**RE:** Wendy's Restaurant  
Grading and Drainage Plan  
Engineer's Stamp Date 2-3-2017 (File: K17D113)

Project Title: Wendy's Restaurant Building Permit #: \_\_\_\_\_ City Drainage #: K17D113

**From:** Cherne, Curtis  
**Sent:** Thursday, January 12, 2017 12:42 PM  
**To:** Jeff Wooten (jeffwooten.pe@gmail.com)  
**Cc:** Al-Najjar, Marwa G.; Biazar, Shahab  
**Subject:** comments/suggestions on Wendy's 4900 Central

PROJECT TITLE WENDY'S RESTAURANT 4900 CENTRAL AVE SE ALBUQUERQUE, NEW MEXICO 87108	DRAWN BY: JEFF WOOTEN	JOB NO. 2016043	SHEET TITLE Grading Plan
DATE 2/3/17	SCALE AS NOTED	SHEET NO. C1.1	OF 1

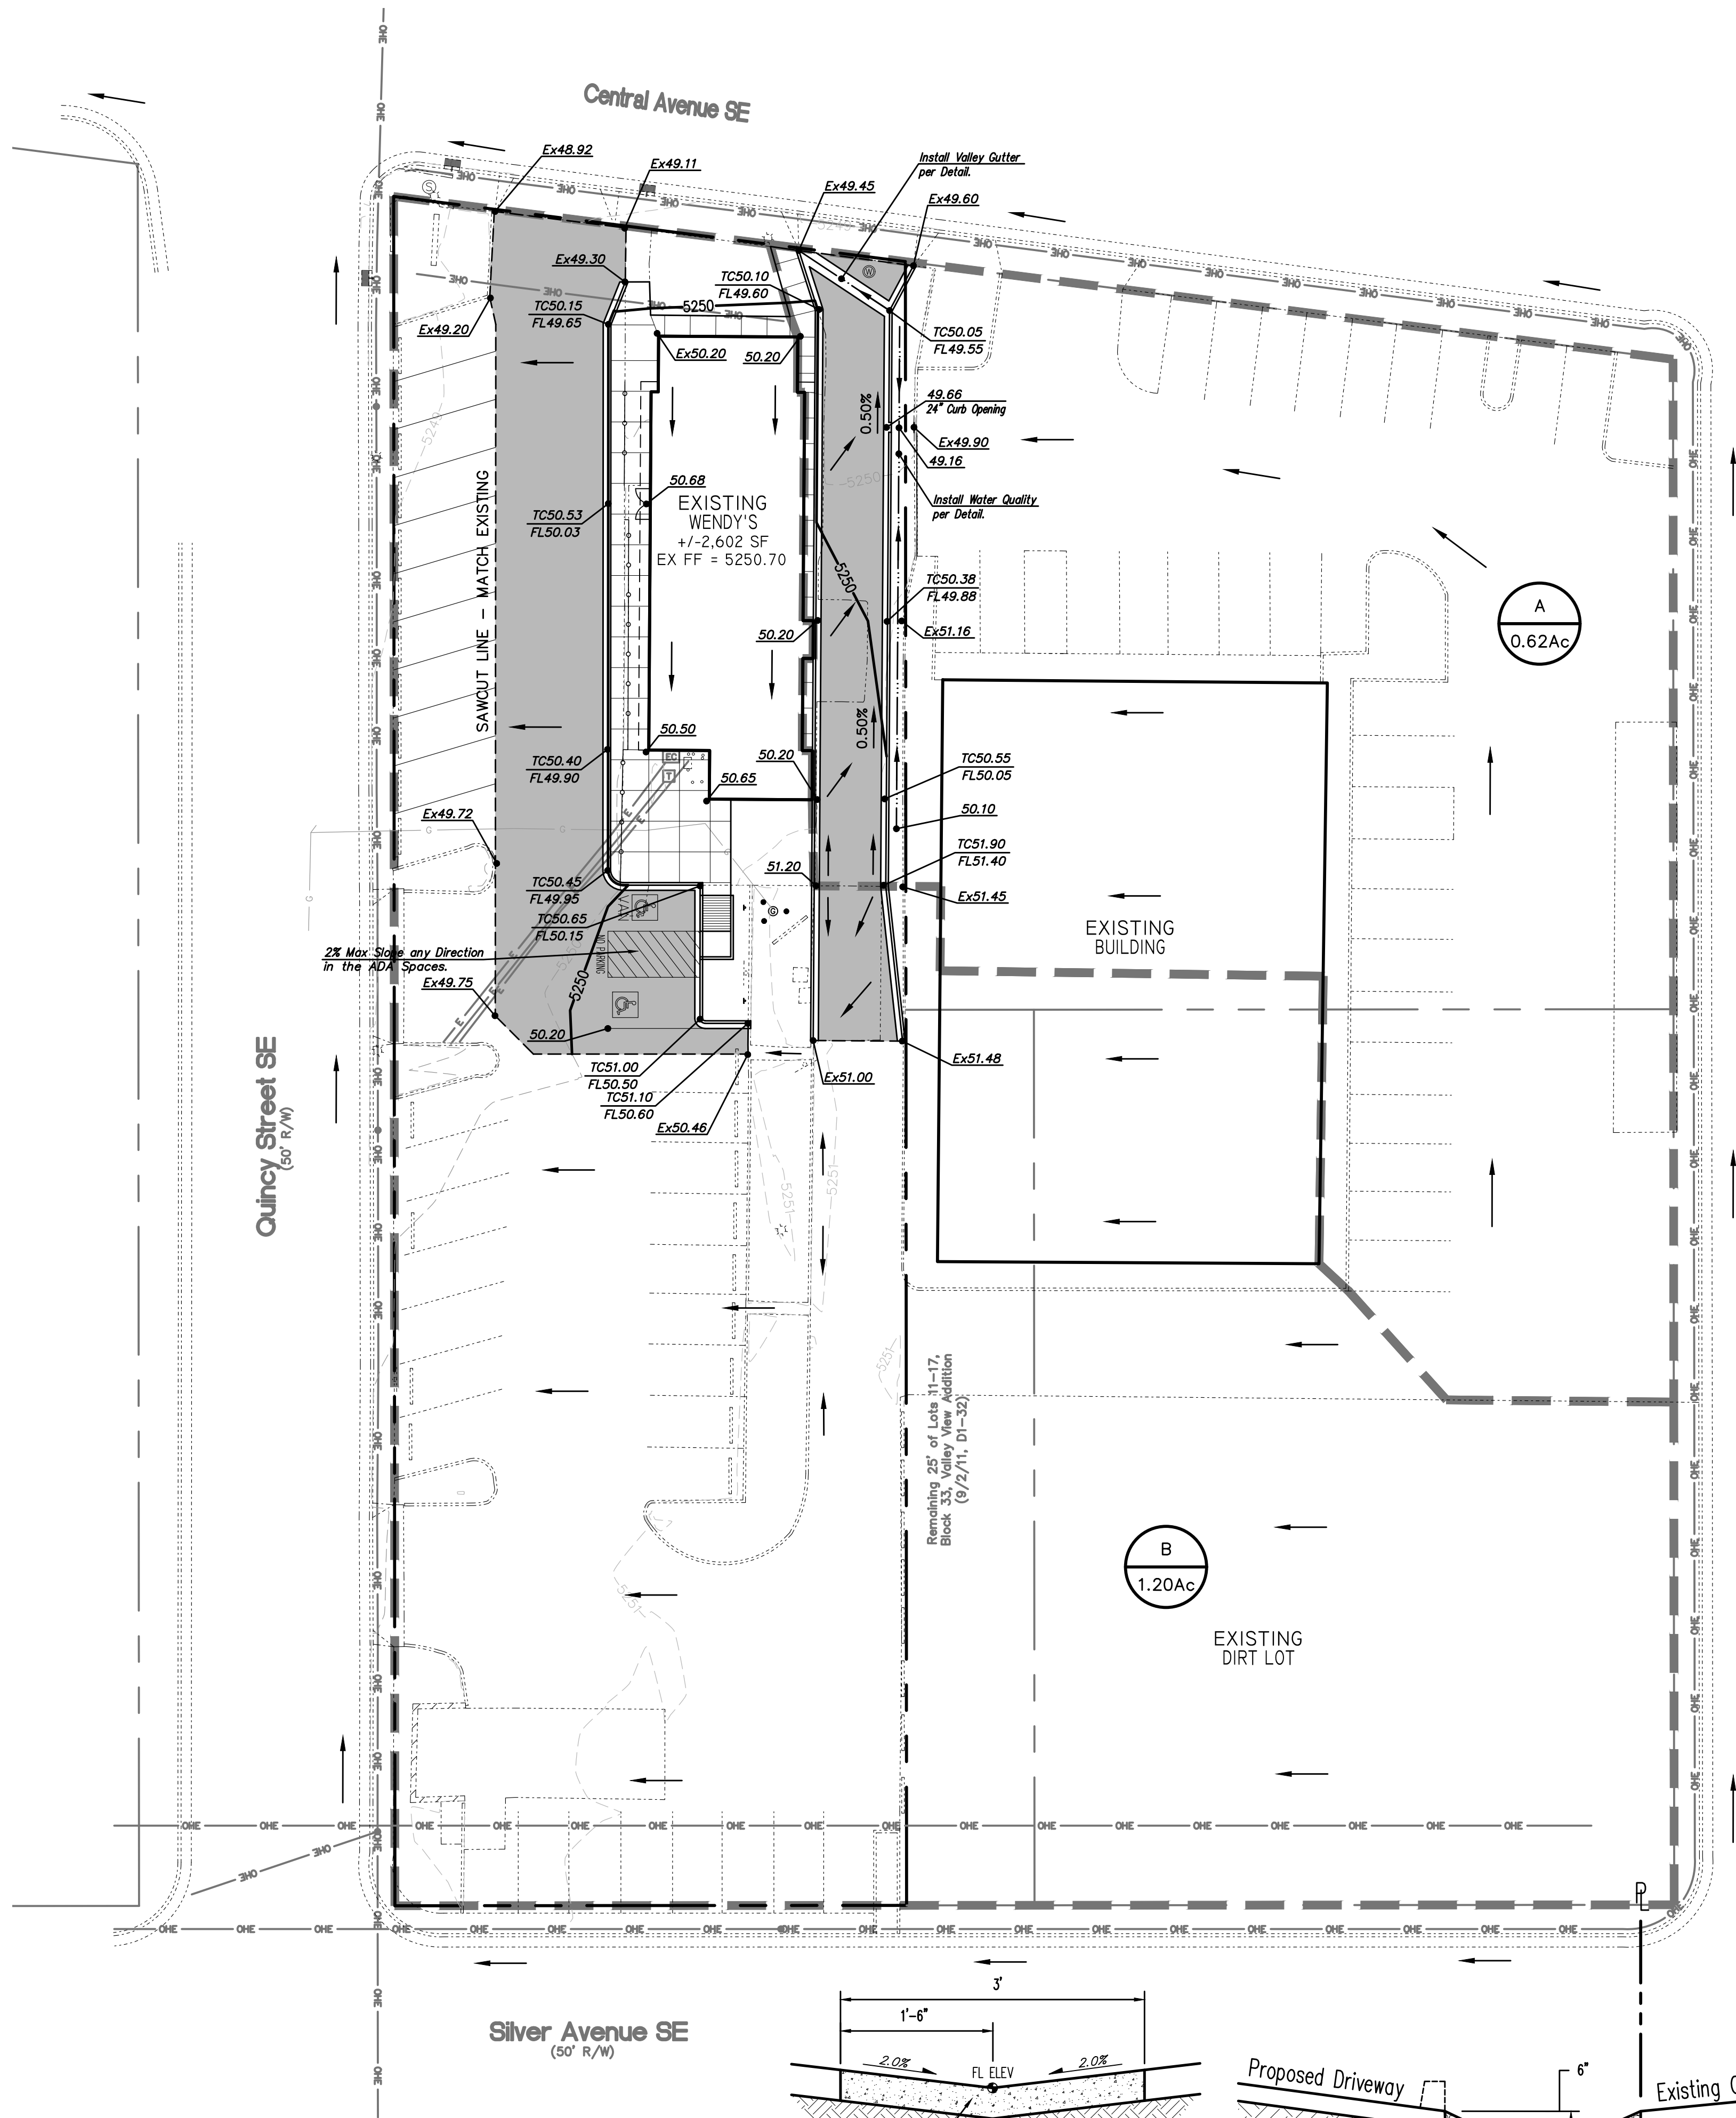
1. Include a narrative. All plans require a narrative.
2. There are offsite flows that drain through an existing curb cut. Either quantify or say something about how the existing curb cut works and should continue to work in the future.

3. Proposed conditions Q and Volume. I don't think you need to provide calcs, but you should mention that proposed flows and volumes will be slightly lower than existing flows and volumes due to the landscaping.

4. It appears to be relatively painless to have flows along the eastern edge drain into the proposed landscape area. Provide curb opening at FL 49.88 and flows could leave the landscaping just upstream of the proposed channel. Section of landscape area could look like landscape buffer swale (5:1 side slopes).

5. It appears that construction of the new channel is partially on the lot to the east. Provide written (email OK) approval from the property owner or authorized agent (e.g. General Manager).
